New House Lot

Address: 71 Quebec St (split from 67 Quebec St)

CHECK-LIST AGAINST ZONING ORDINANCE

Plan Depicting The Results Of A Boundary Survey
And Proposed Division Lines
Made For
Quebec LLC
Northwesterly Sideline Of Quebec Street
PORTLAND, MAINE

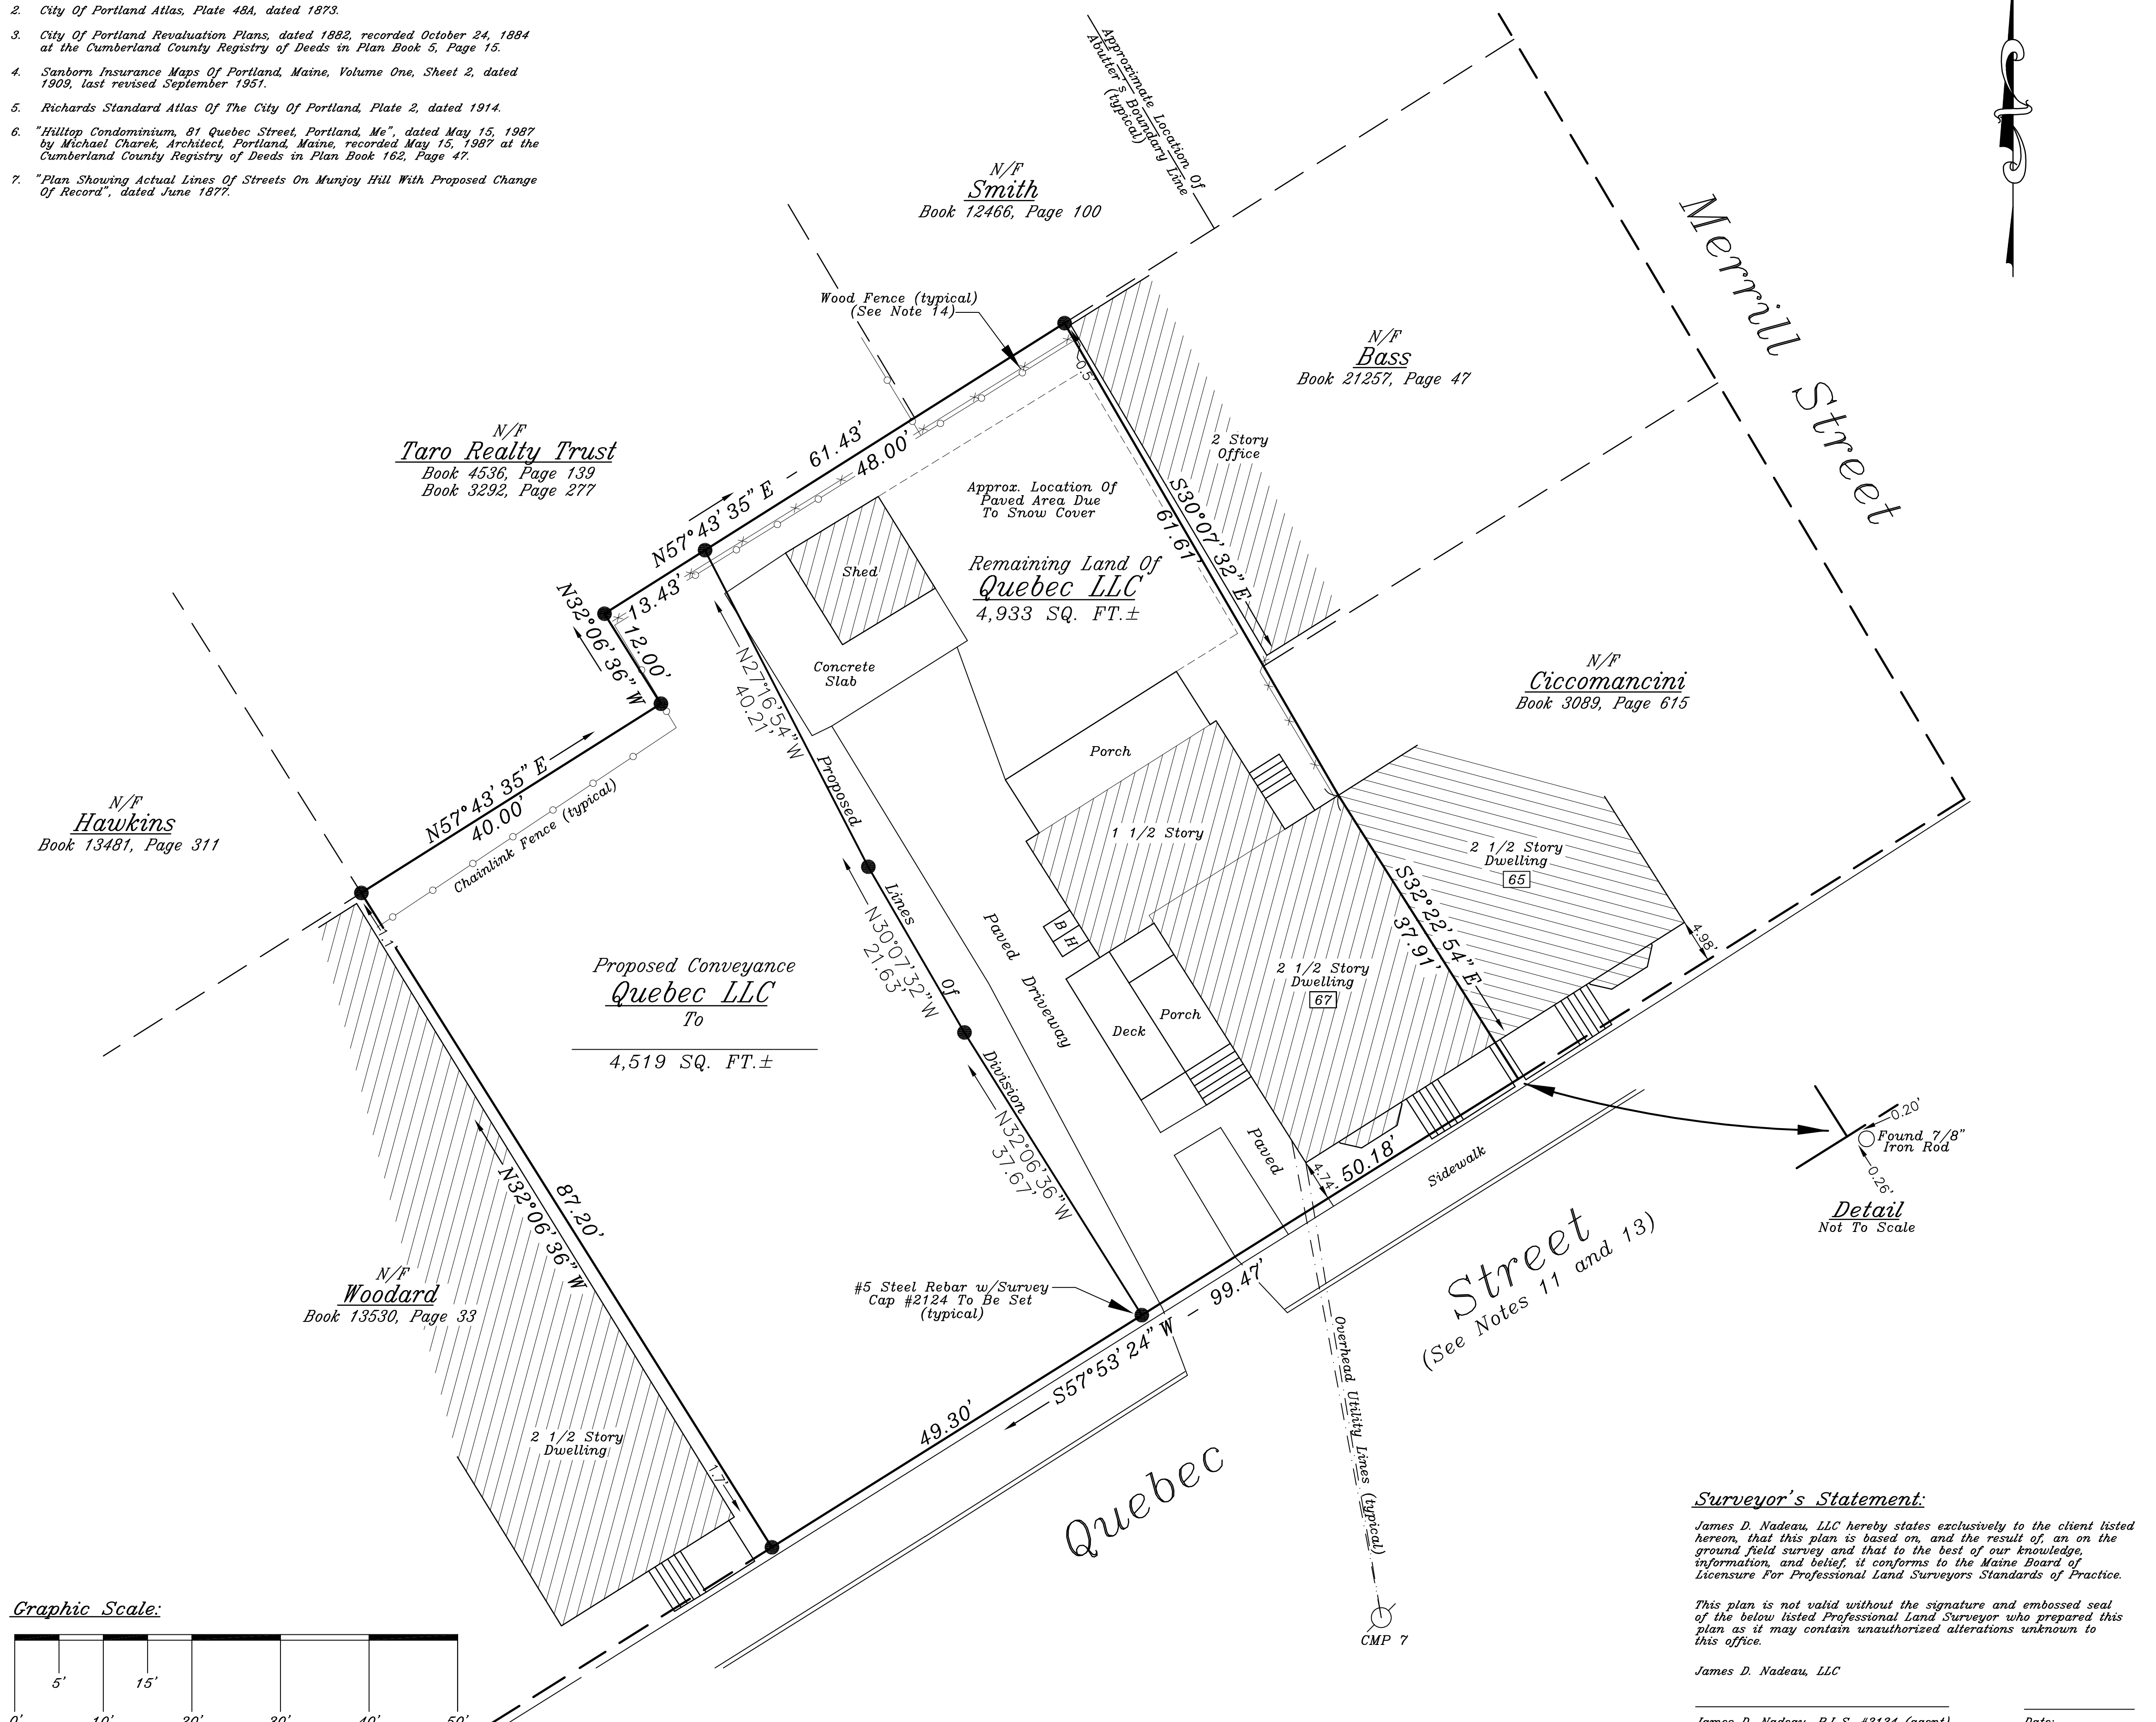
Lot Street Frontage - 40' min - 49.3' s/w <sup>boundary survey</sup> (OK)

Width of Lot - 40' min - 44.38' scaled (OK)

Lot Area - 4500 sq ft min - 4519 sq ft on boundary survey (OK)
